KITTITAS COUNTY

MEMORANDUM

TO: All Staff
FROM: Public Works Plan Review Team
DATE: June 26, 2026
SUBJECT: BL-26-00007 Flying A Land LLC

**RECORD OF SURVEY**  
 A PORTION OF THE NW 1/4 OF SECTION 32,  
 TOWNSHIP 18 NORTH, RANGE 19 EAST, W.M., KITTITAS COUNTY, WASHINGTON

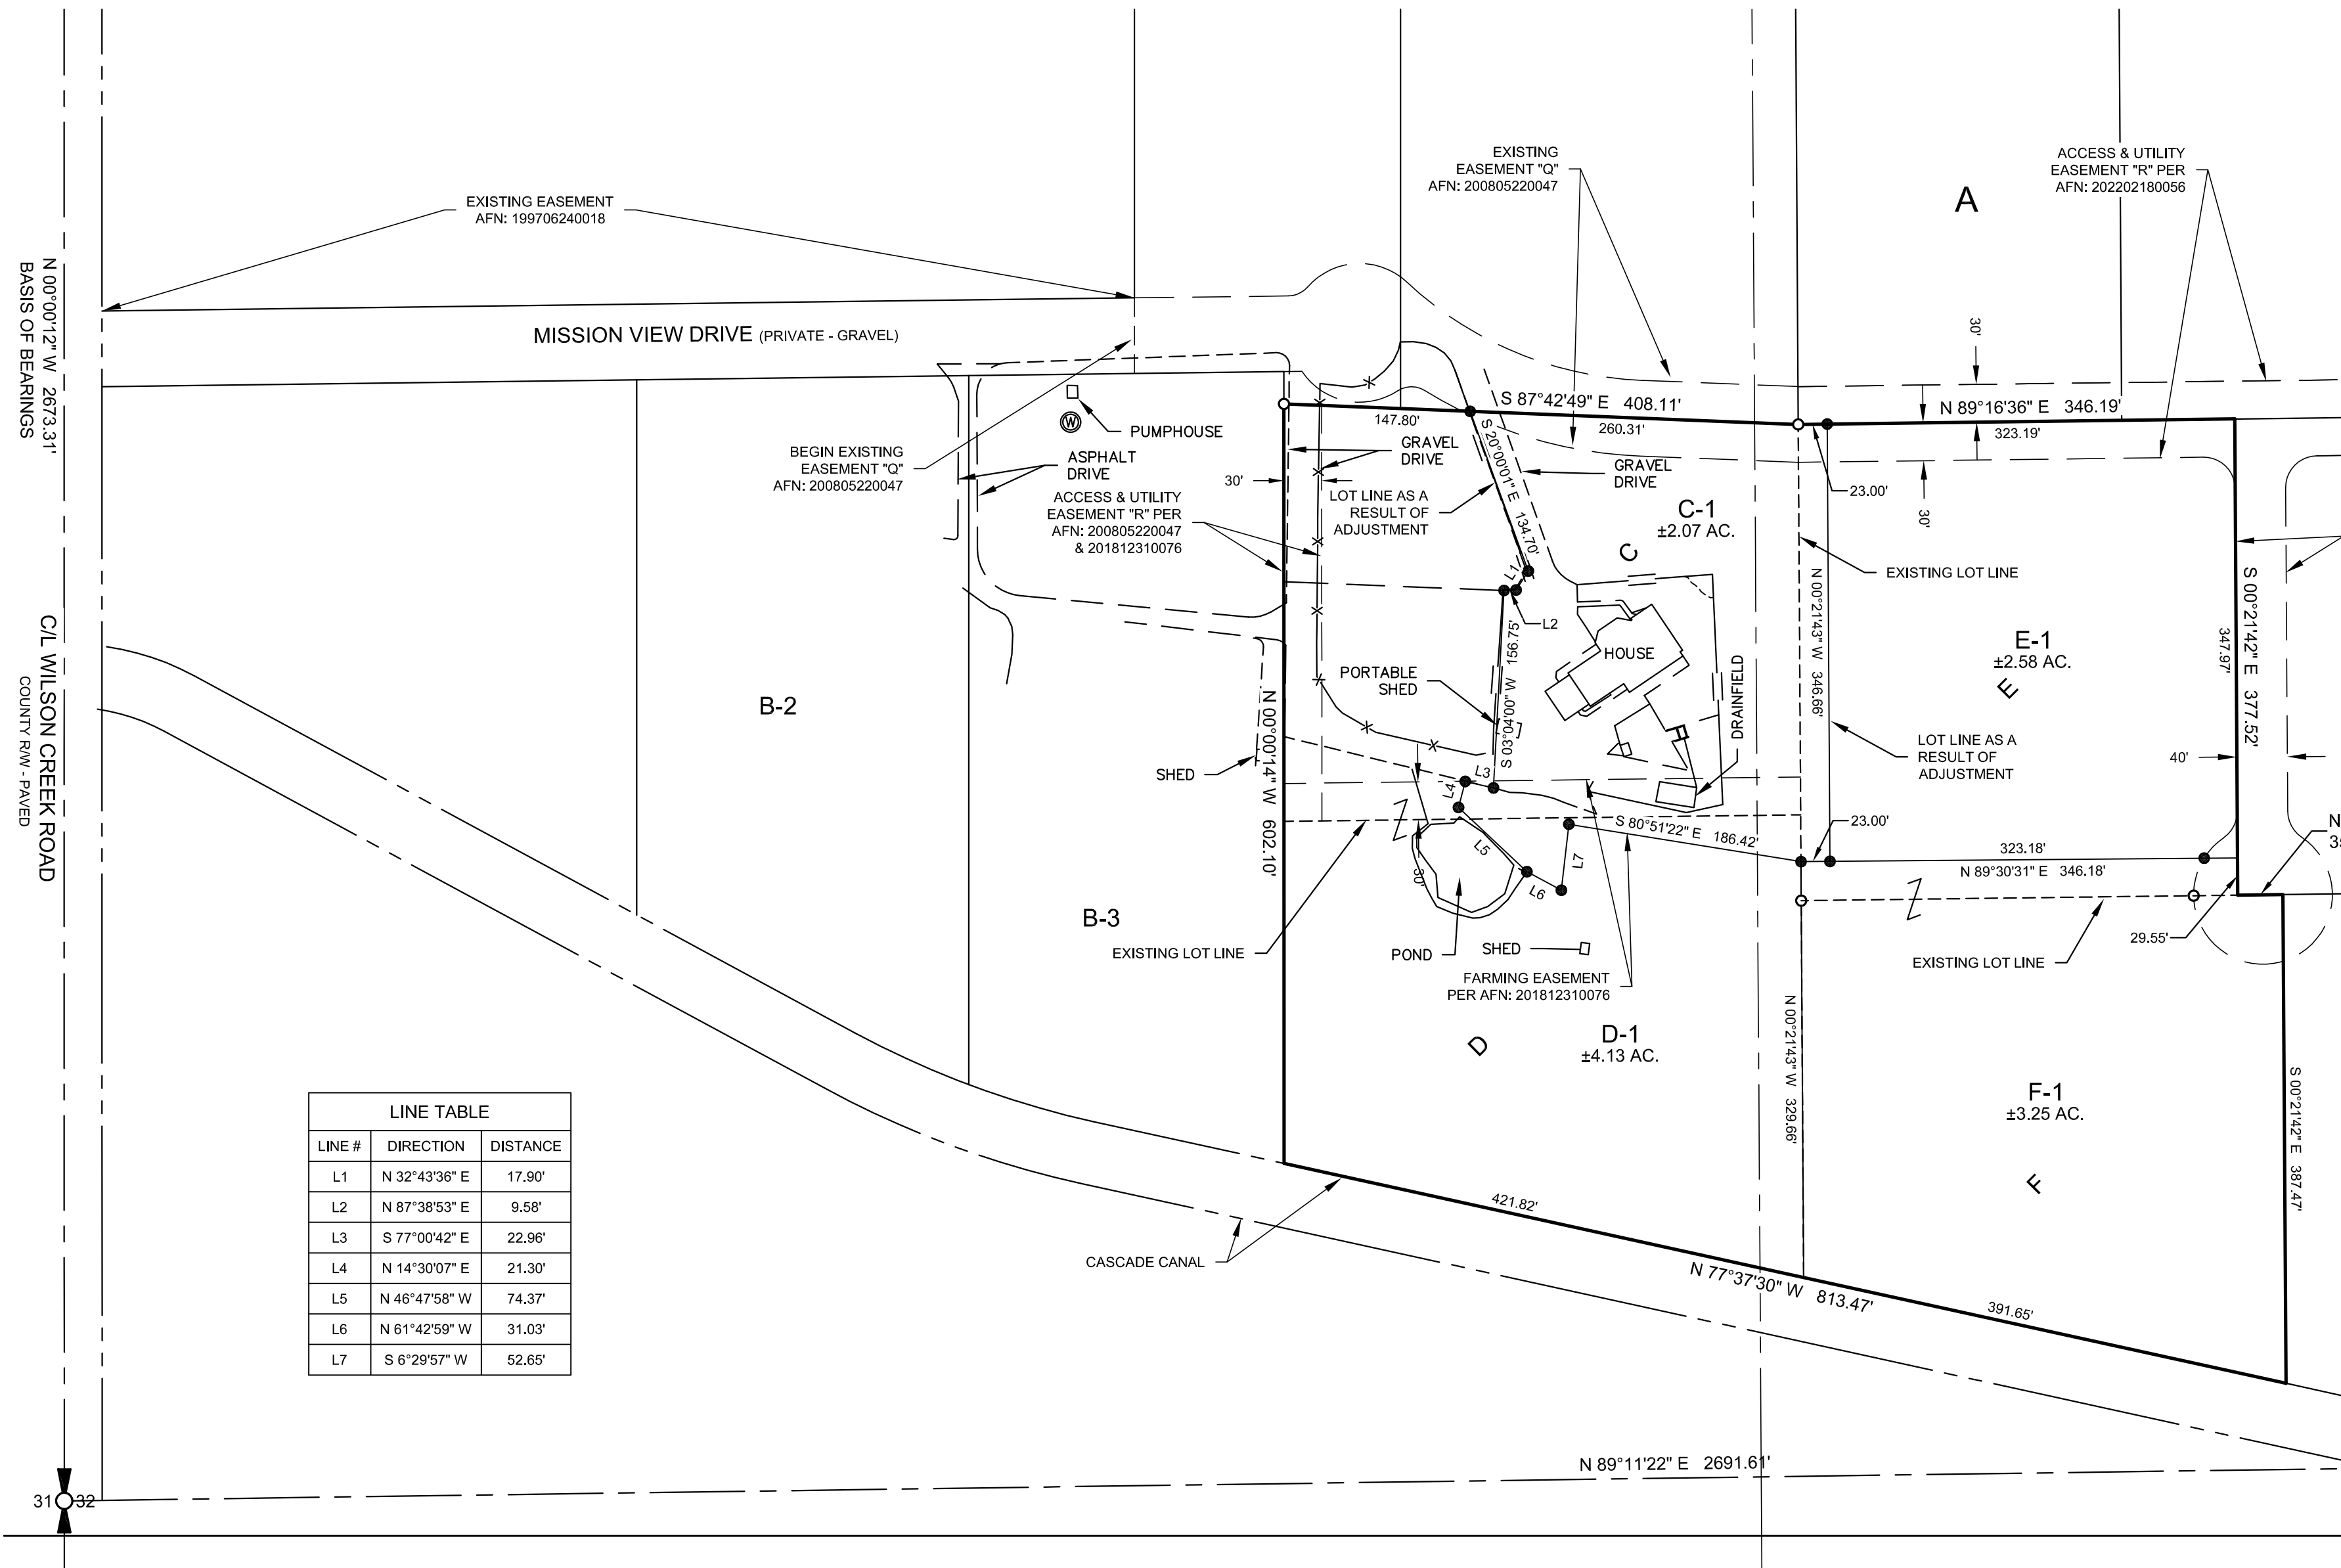
SURVEY	1. Please Show R/W width for Wilson Creek Road, Mission View Drive and Cascade Canal. 2. The Basis of Bearing shown has no ties to the survey of the subject parcel. 3. There are insufficient ties to existing Survey control. 4. Please include description of Section corner shown (Found? Set? Calc?). 5. For existing lots, please include recording information (EX: B-2, SP:E-170 OR Bk: E Short Plats, Pg:170 OR AFN:199706240018) 6. The map is missing a Legend. 7. There are labels that have been cut off to the East of Lot E-1. 8. Some dimensions have been obscured by crossing linework. 9. If any of the property corners shown were utilized as survey control, there should be distance ties to them. 10. The map is missing an Equipment and Procedures Note. 11. The map is missing a Purpose of Survey Note. 12. Closures were not provided with the application. Closures will need to be reviewed prior to final approval. This may result in additional required changes. (JT)
